Recommendation Report for Works to Tree(s) on trees subject to a Tree Preservation Order (

REF NO: AW/305/17/T

LOCATION: 8 Apple Grove
Aldwick

PROPOSAL: Remove 4m of southwest facing bough & deadwood 1 No. Monterey Pine tree.

REMOVE THIS
4m BRANCH

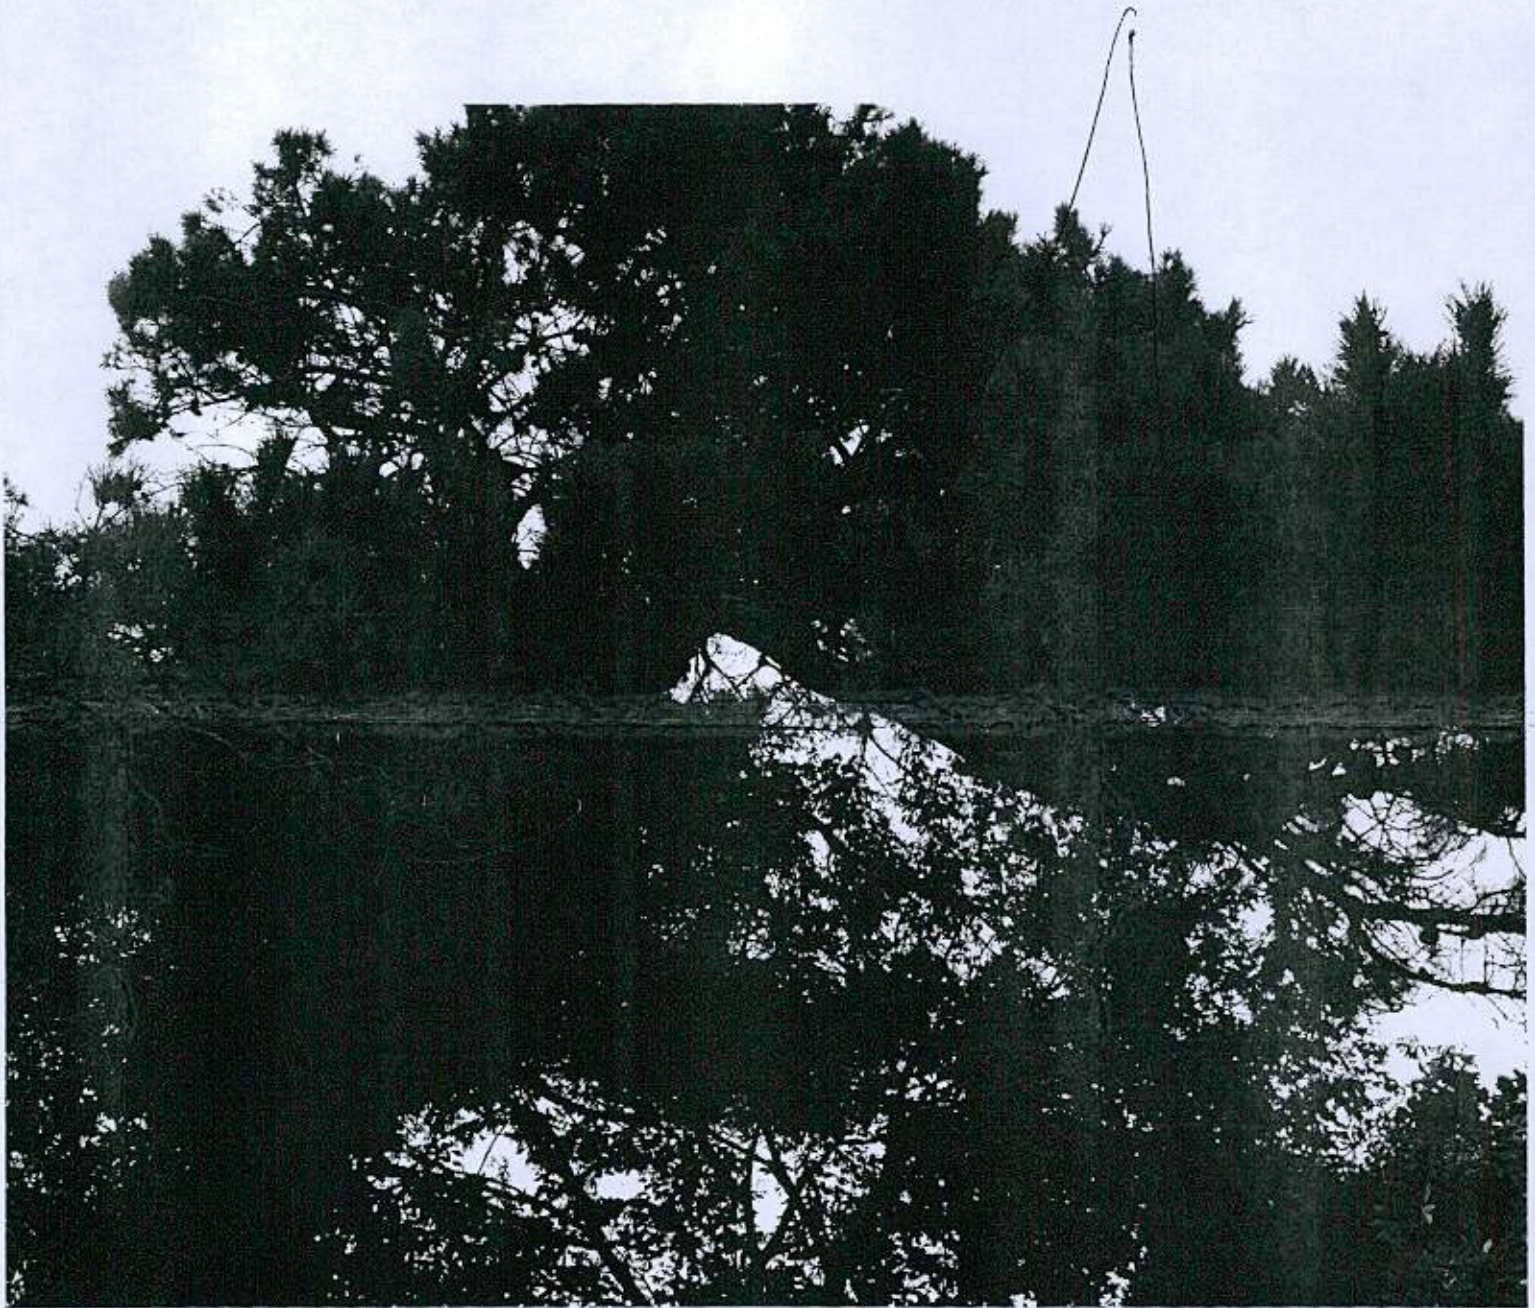
- Situated in the small rear garden of this property.
- Sound and healthy tree that is visually significant in the landscape.
- Has one low attenuated limb to the southwest facing side that is out of character with the remainder of the crown.
- Due to the dark foliage this tree causes light issues all year round.

- This shortening back of the low limb will provide significant benefit for the owners without detracting from this trees visual amenity value in the landscape.
- The removal of deadwood does not require Council approval.

- Where branches are to be shortened back the final cuts are to be made at the correct angle shown in BS3998:2010 and adjacent to a live bud or lateral.
